Please ask for: Nicola Moore
Email: nicola.moore@arun.gov.uk
Telephone: Ext 37944
Our Ref: FP/58/20/CLP
Your Ref:
Date: 9th April 2020

Lawful Development Certificate for a Proposed Use or Development

Development: Lawful development certificate for minor internal alterations to the ground floor retail unit and change of use from A1 (shop) to A2 (financial and professional services)
Location: 82 Flansham Lane Felpham PO22 6AH

TITLE  
Existing &  
Proposed

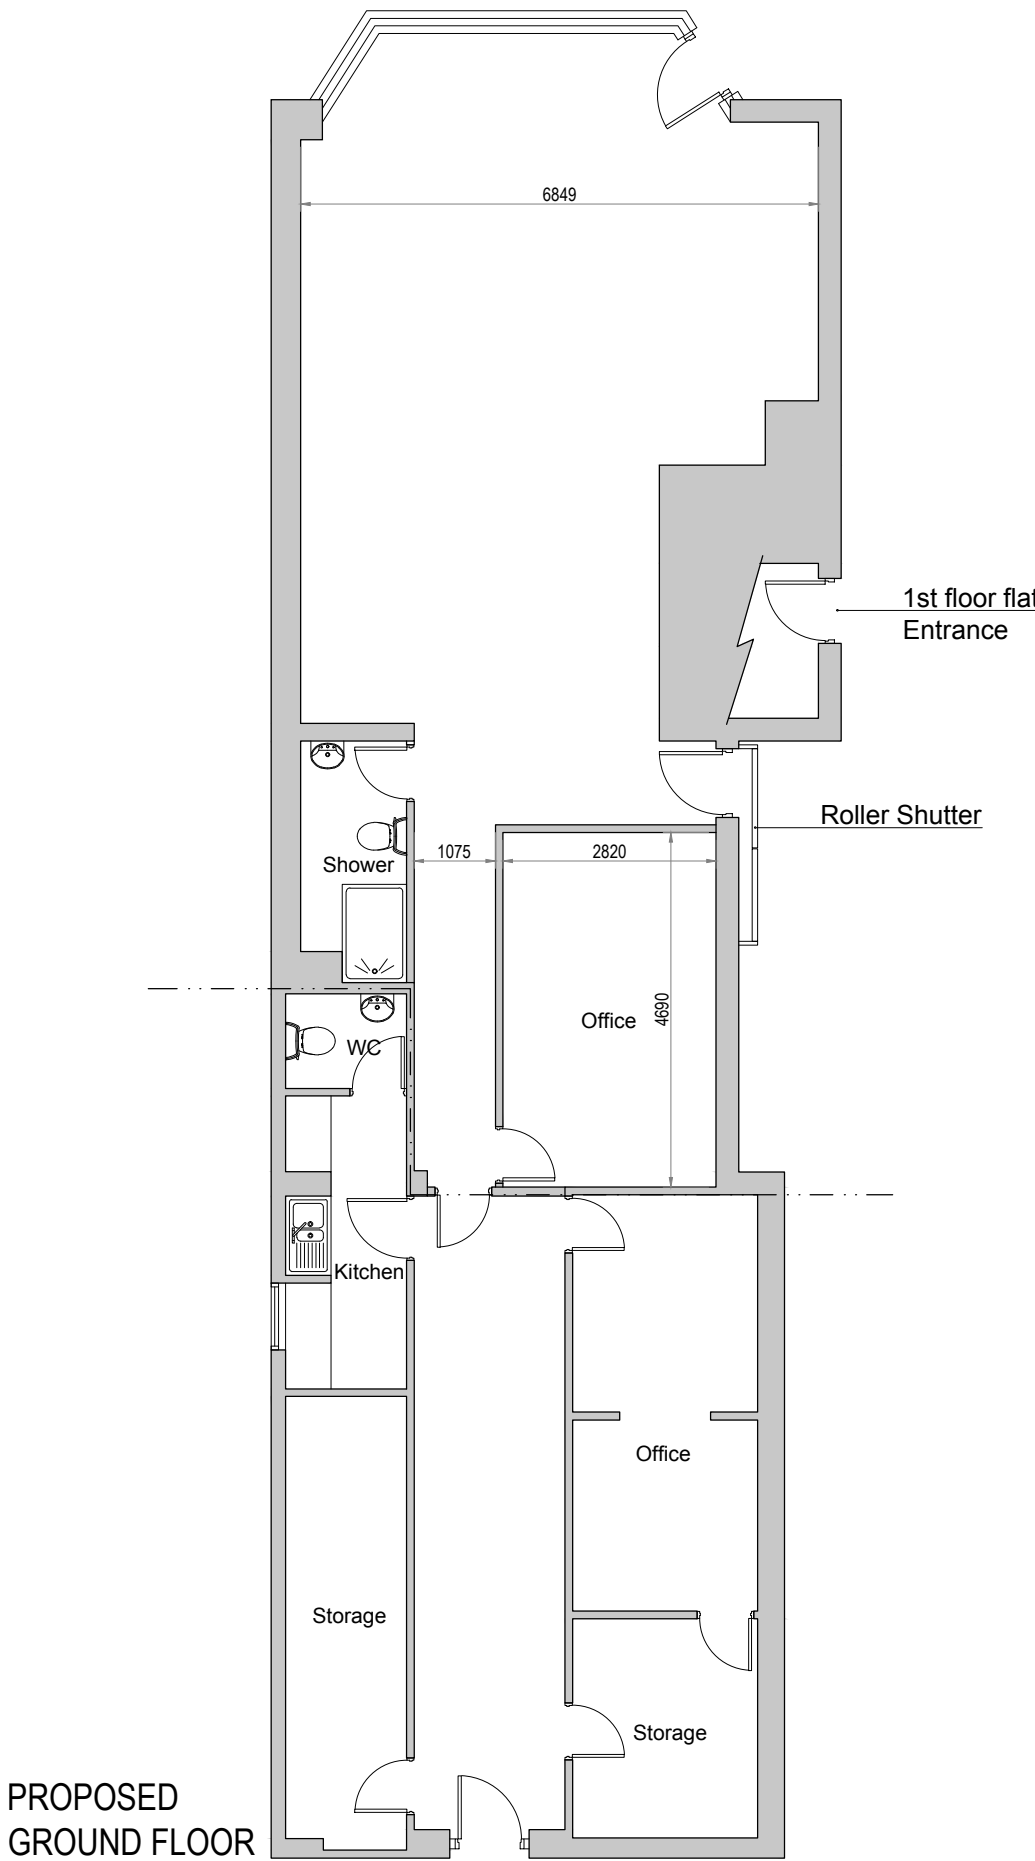
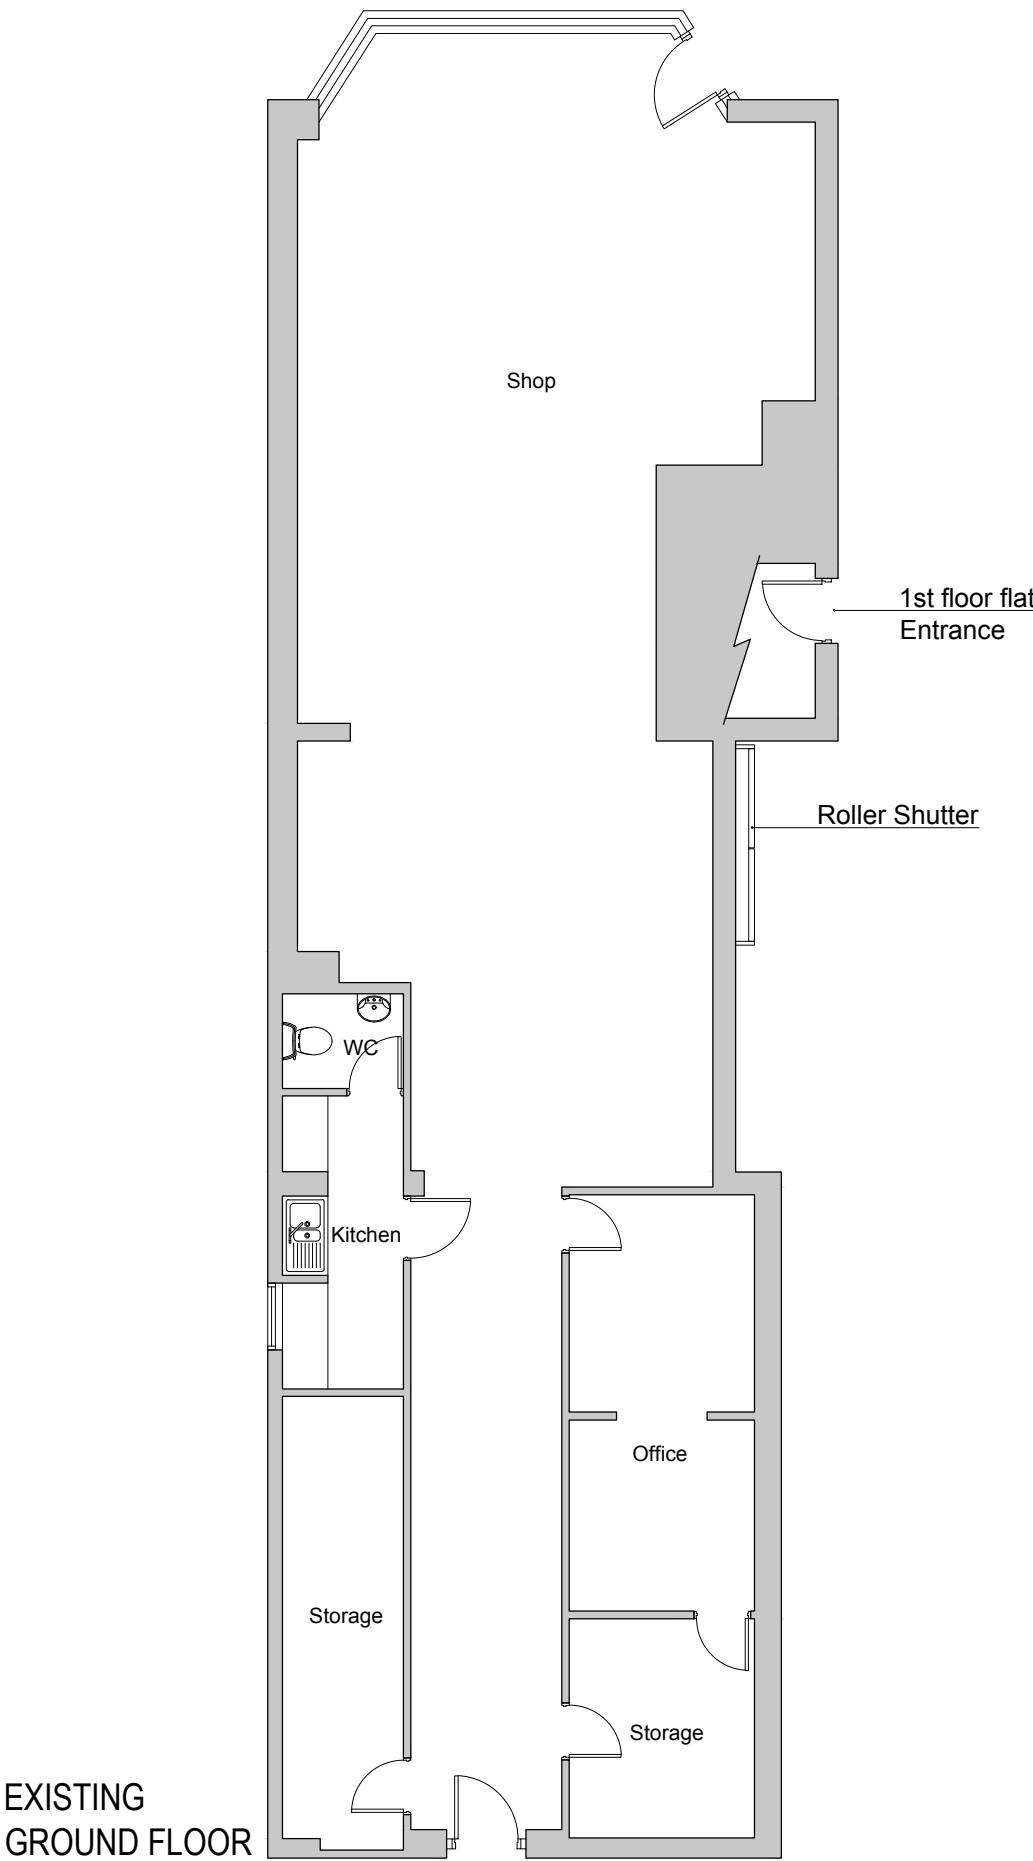
Please submit existing and proposed elevations as the proposed floor plan shows a door on the side.
